Further to our previous email responding to the conservation officers comments on Mill Cottage - I attach a detail of window shutters in flint walls. We are not yet able to confirm the stone paving spec for the external terrace and ask that this may be a condition prior to commencement of this part of work only along with the sample panel of new garden wall.

We have read through Martyn White's (Conservation officer) comments on Mill Cottage applications CM/38/19/PL and CM/39/19/L which are very useful and encouraging and we would like to confirm and respond as follows:

Mill Cottage:

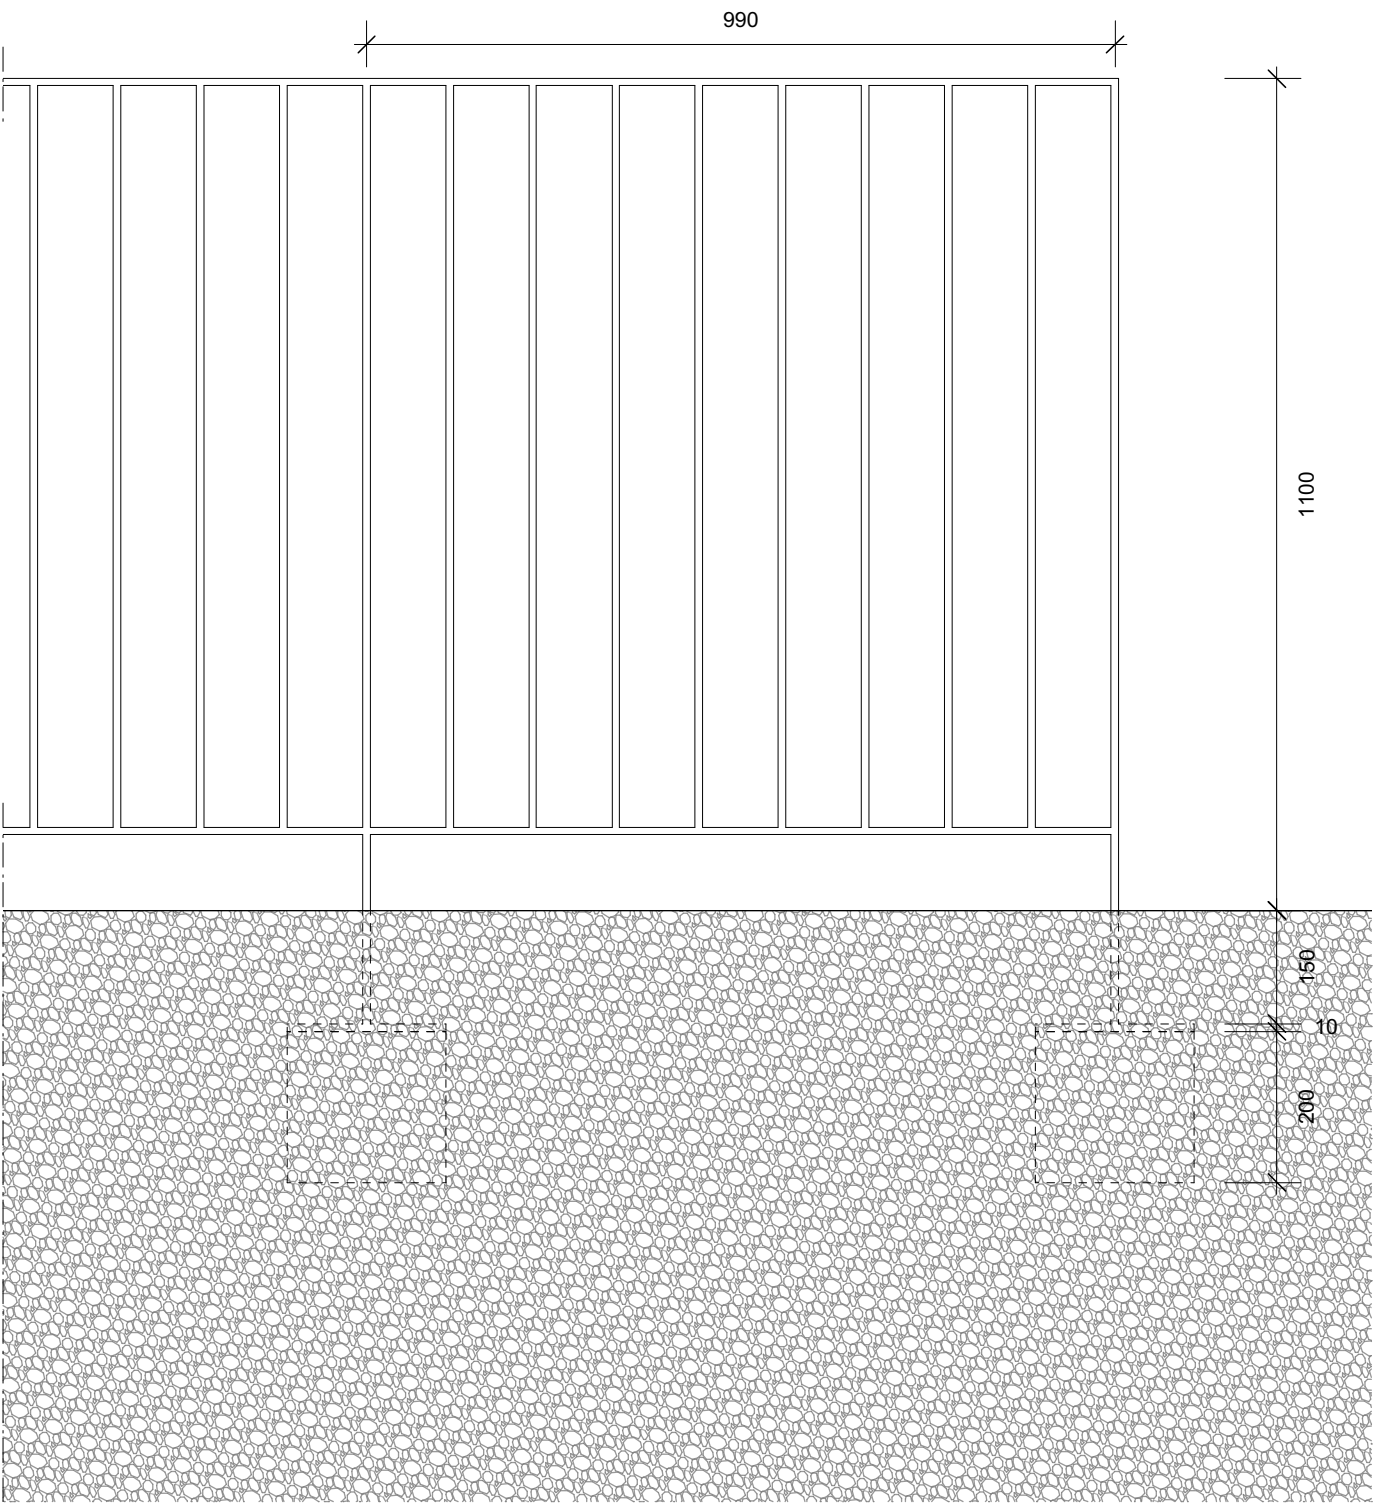
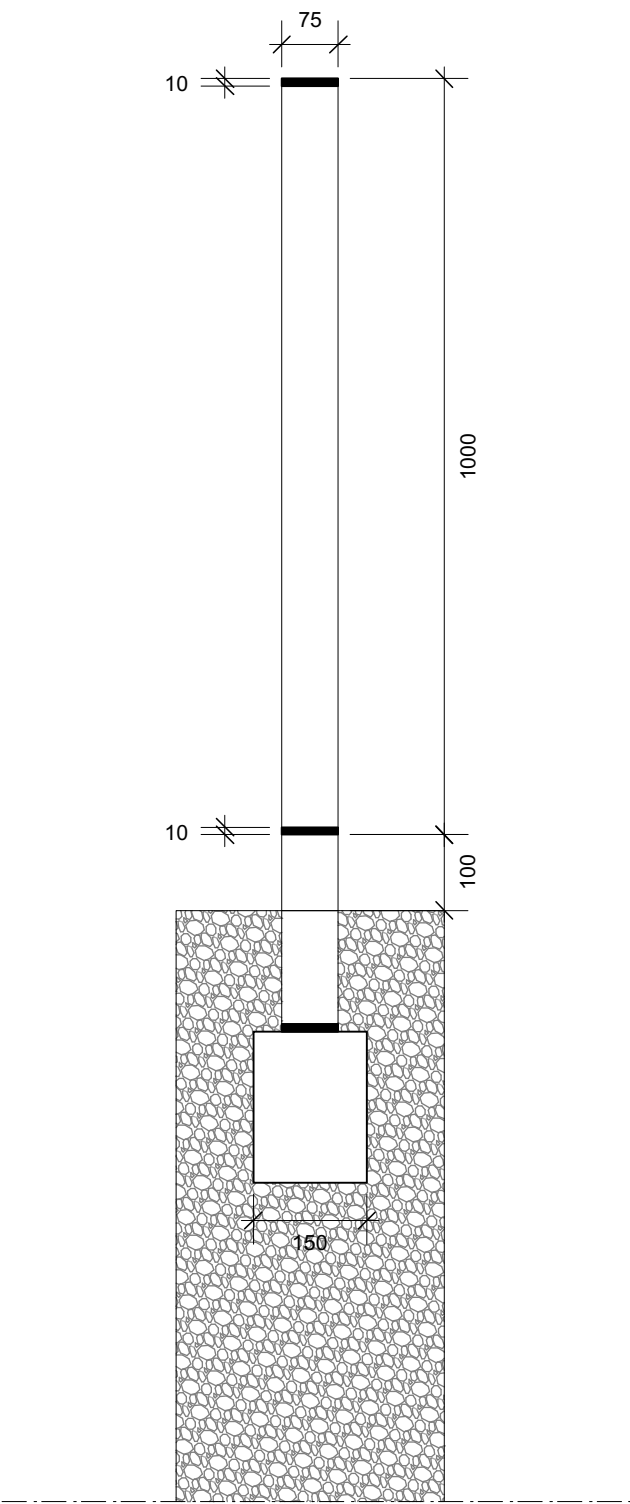
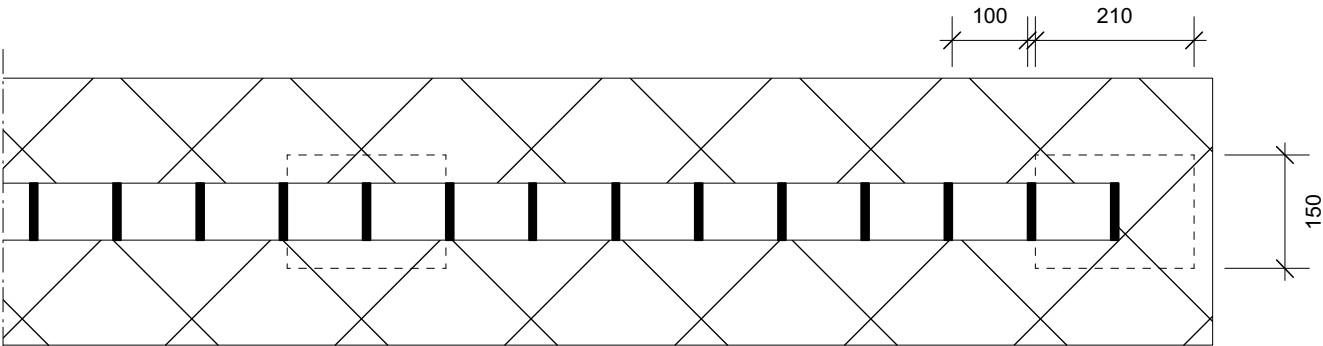
- Internal flooring - we confirm the floors are replacement concrete slab with polished concrete screed finish.
- We can confirm the balustrade will be painted not sprayed.
-

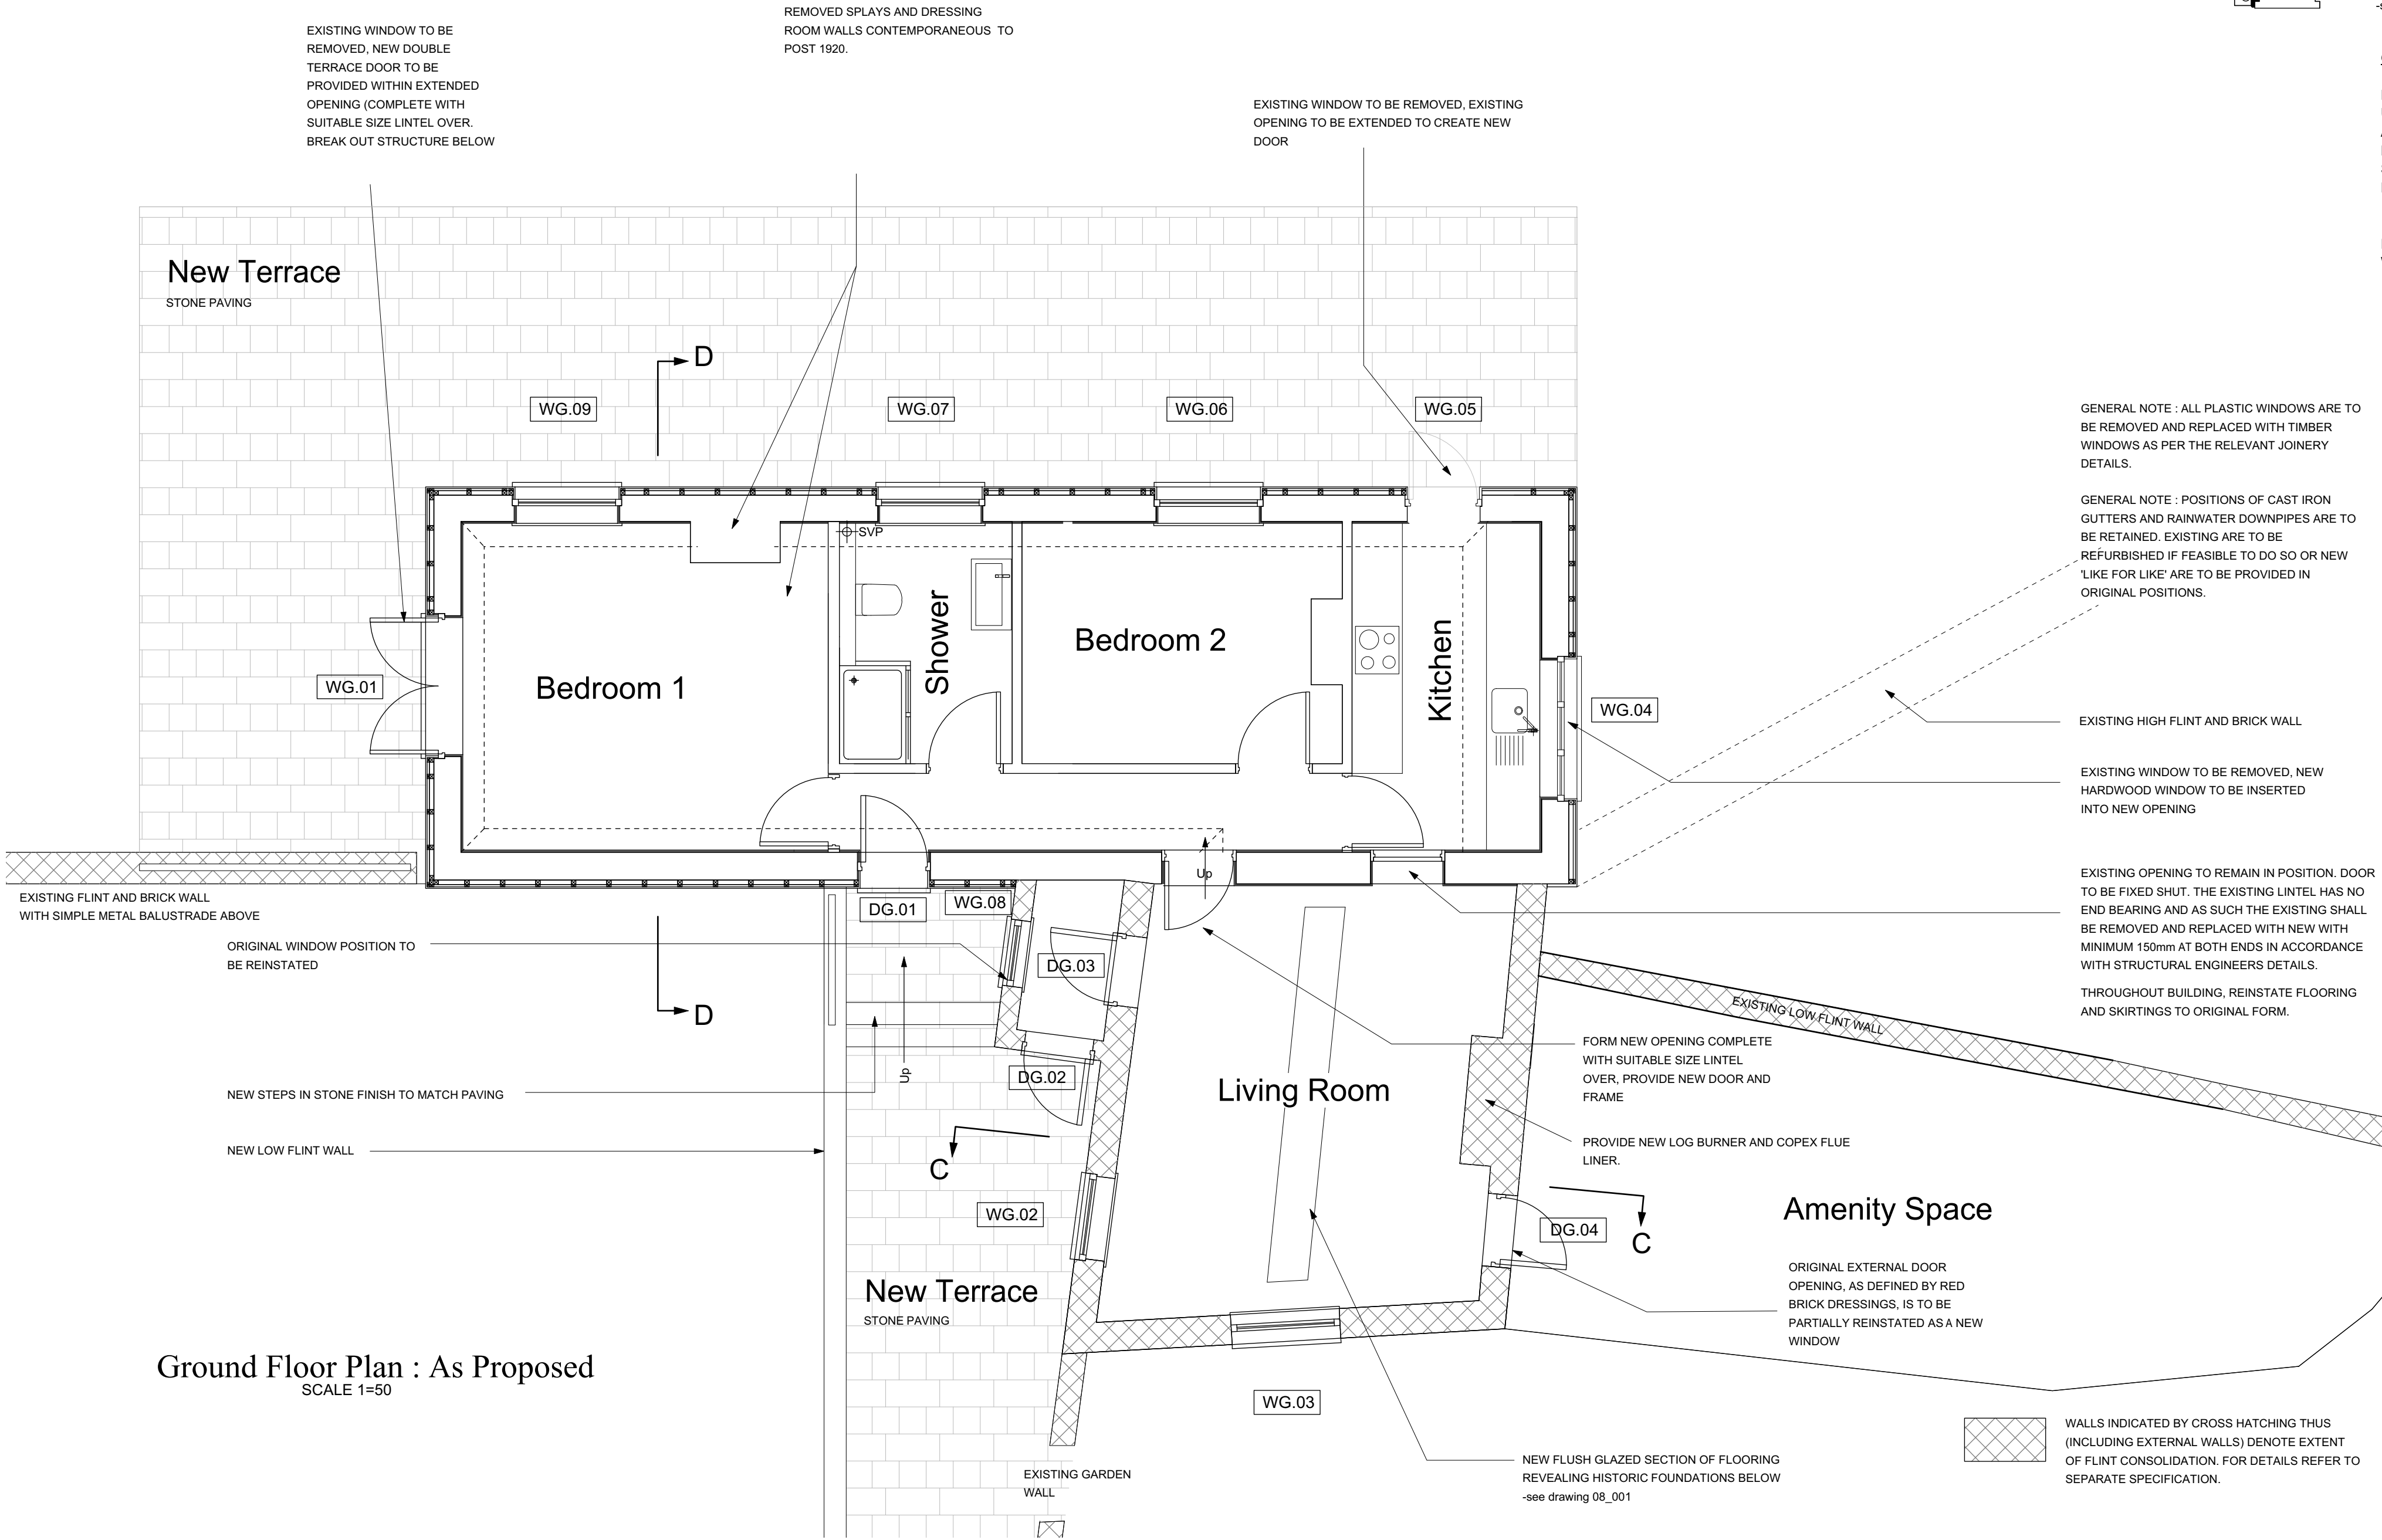
- Shutters detail to windows in flint walls
- Detail of stone paving specification on external terrace
-

- We can provide a sample panel of new walling to front terrace - can this be a condition prior to commencement of this part of work only?
